Civil Engineering Impacts on Existing Tree Cover

**Hammond Ground, Read in respect of
Application No. 3/2026/0356**

**For the erection of 77 no. dwellings and creation of
community parkland with vehicular access from Whalley
Road and associated infrastructure, parking and landscaping**

Technical Working Notes – Earthworks, Trees and Enabling Works

ROAD 1 - LONGSECTION
SCALE: H 1:500,V 1:100, DATUM: 95.000

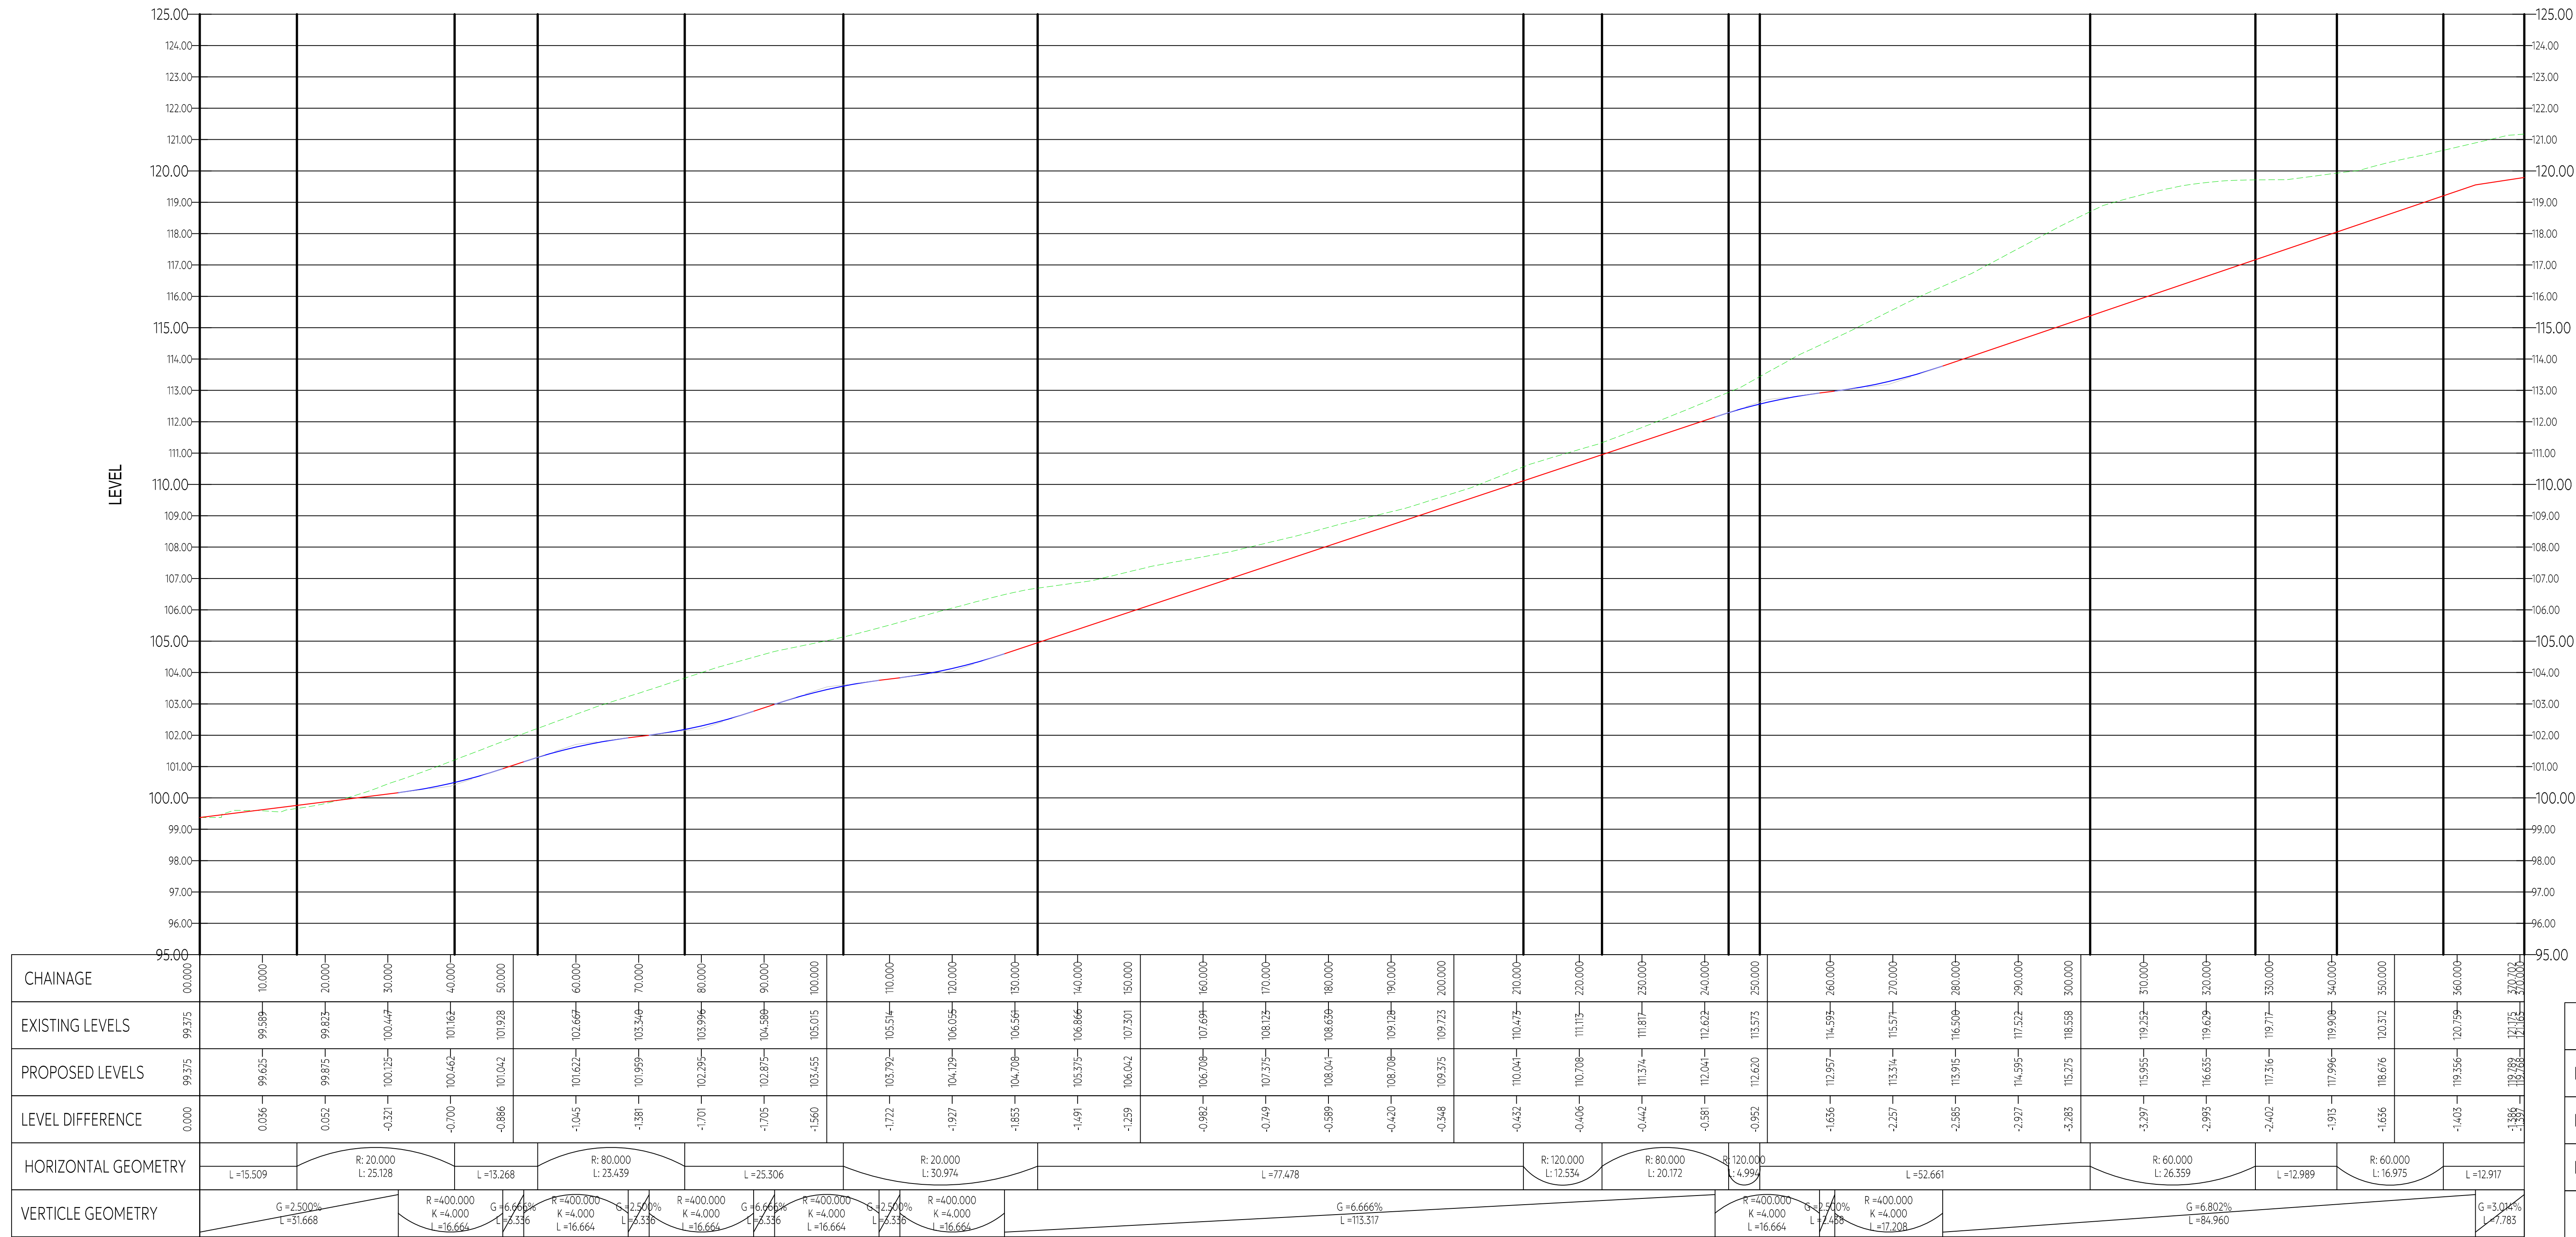
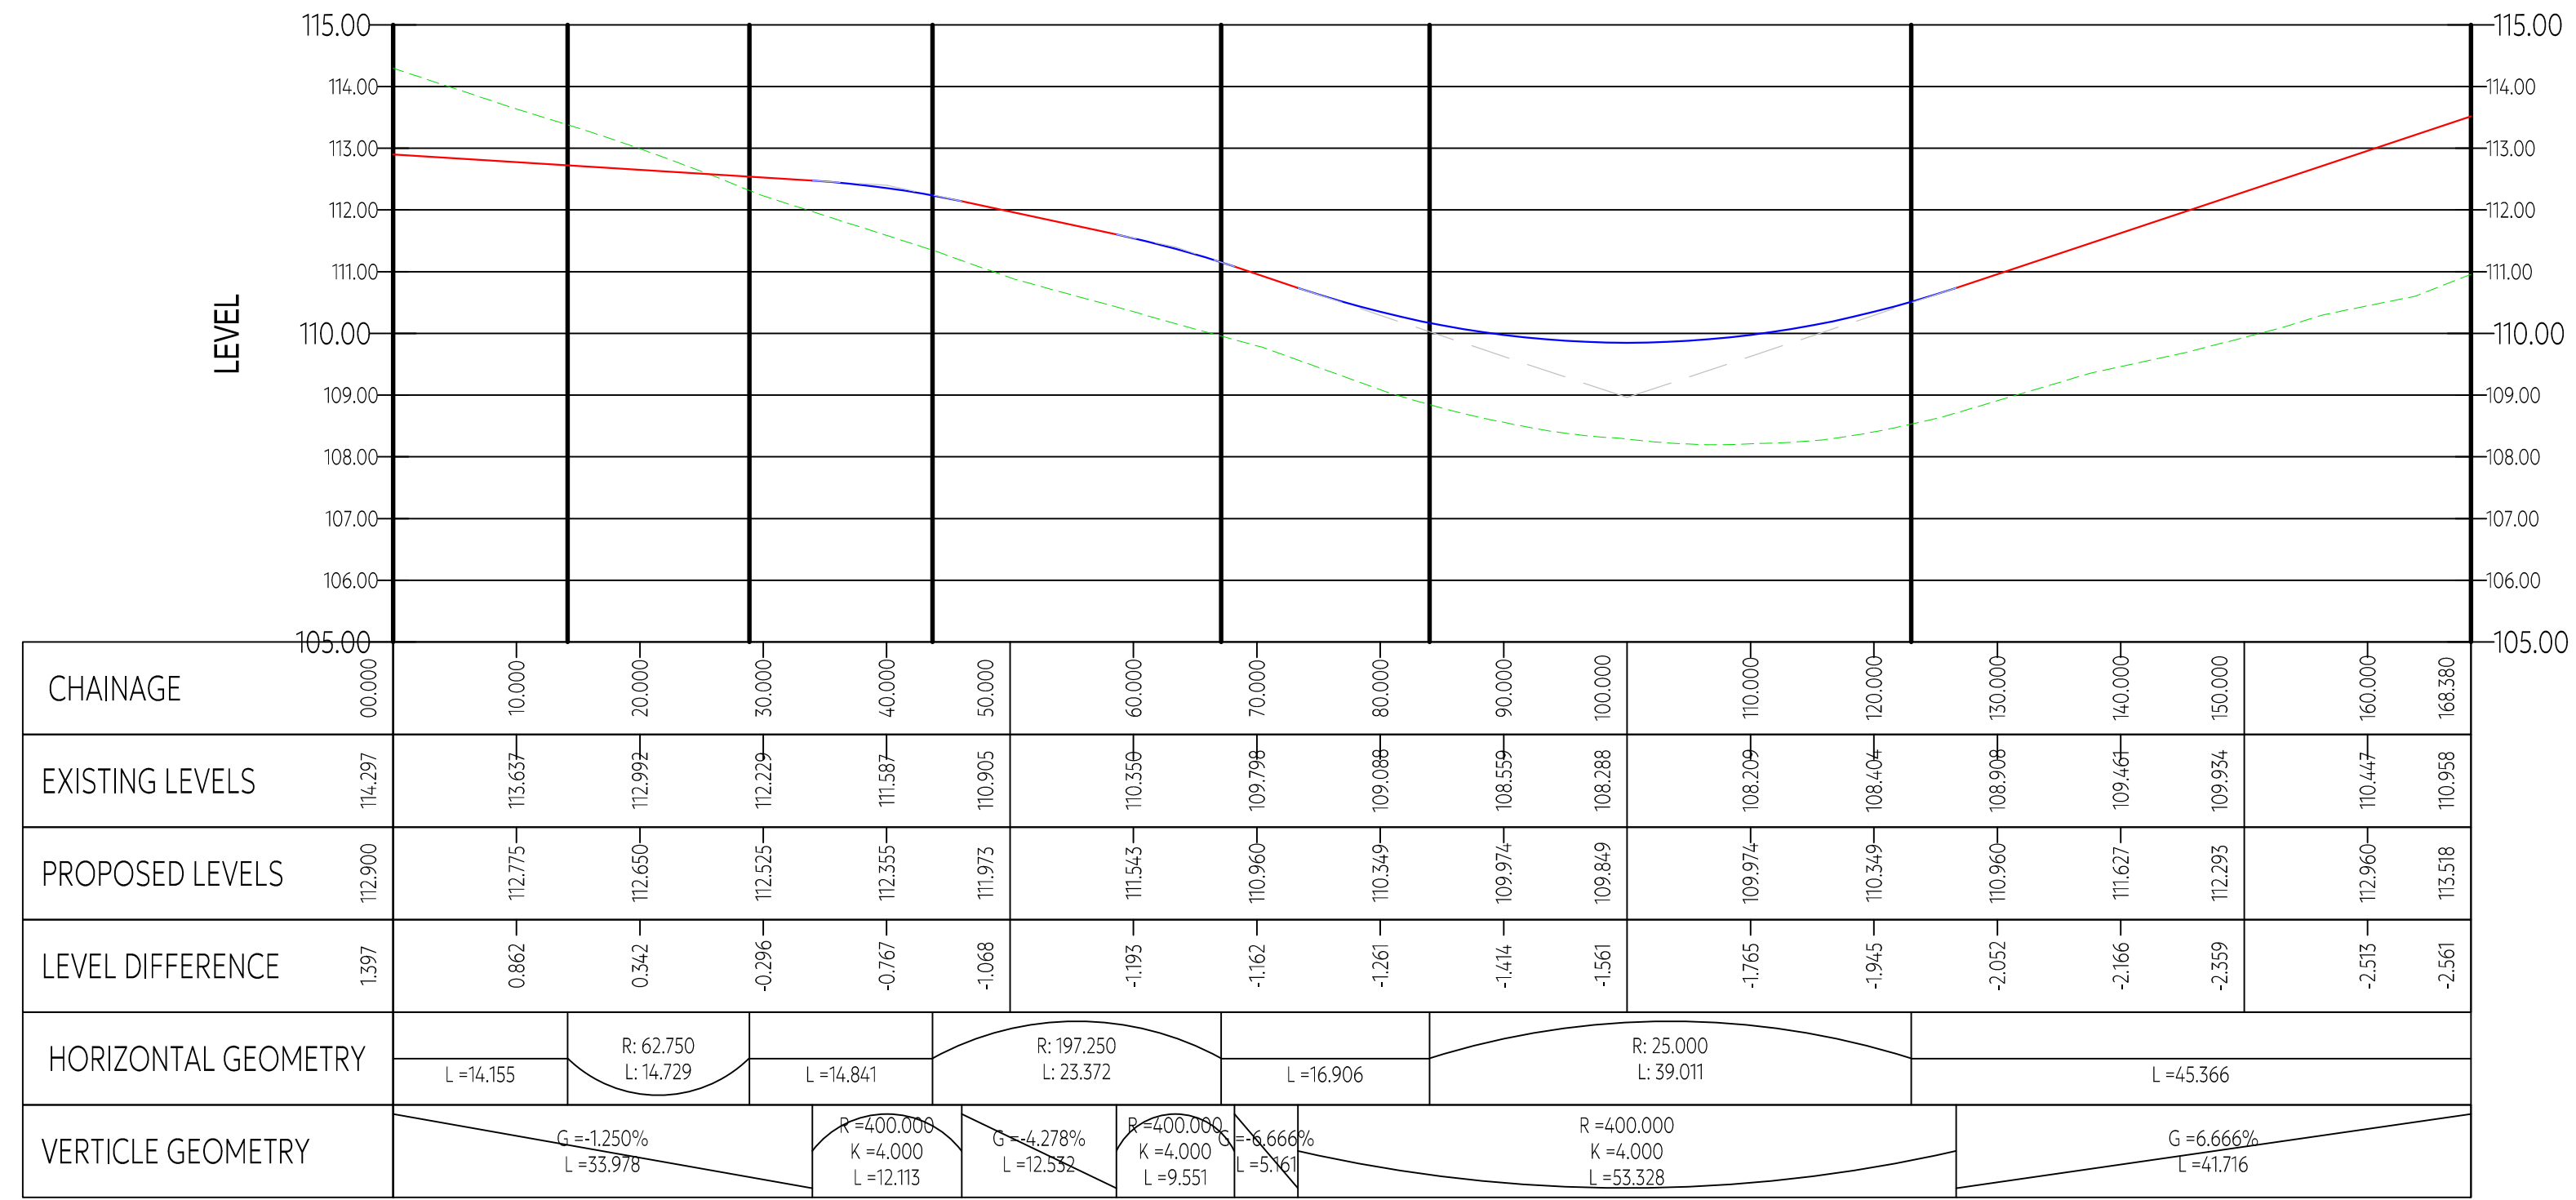
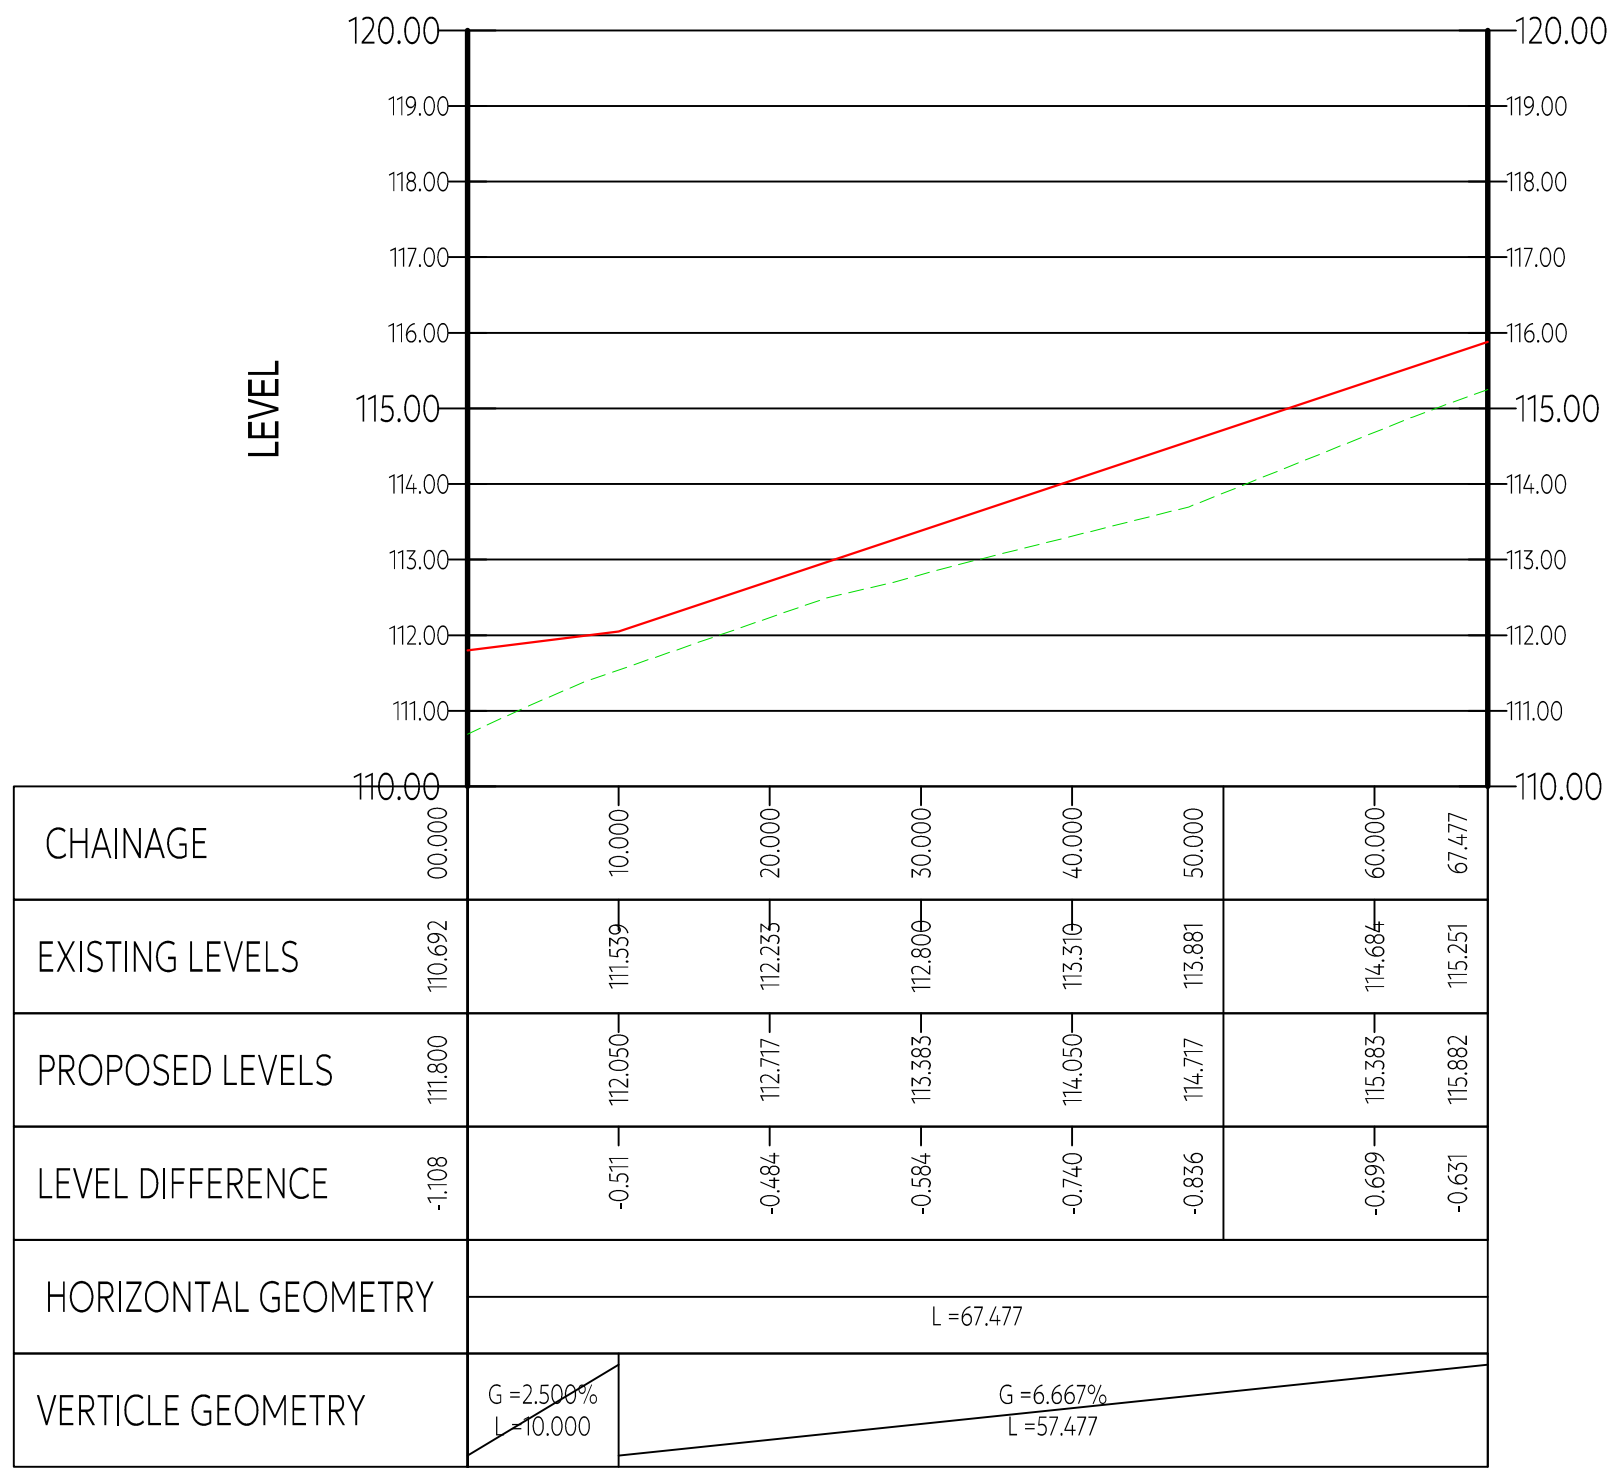
- The highway sections show significant differences between existing and proposed ground levels in several locations, including areas where approximately 3-4 metres of level change appears to be proposed.

- The highway section indicates approximately **3 metres** difference between the existing and proposed ground levels.
- The adjacent External Works drawing shows a retained mature tree within close proximity to these proposed works.
- The submitted drawings also indicate that existing ground levels around retained trees should remain unchanged.
- Based on the information currently submitted, I cannot reconcile how these proposed earthworks can be undertaken whilst maintaining the existing ground levels around the retained tree.
- Additional engineering and arboricultural detail would help explain how this constraint is intended to be managed.

How can the proposed changes in ground levels be achieved whilst maintaining the existing ground levels around this retained tree, as indicated elsewhere on the submitted drawings?
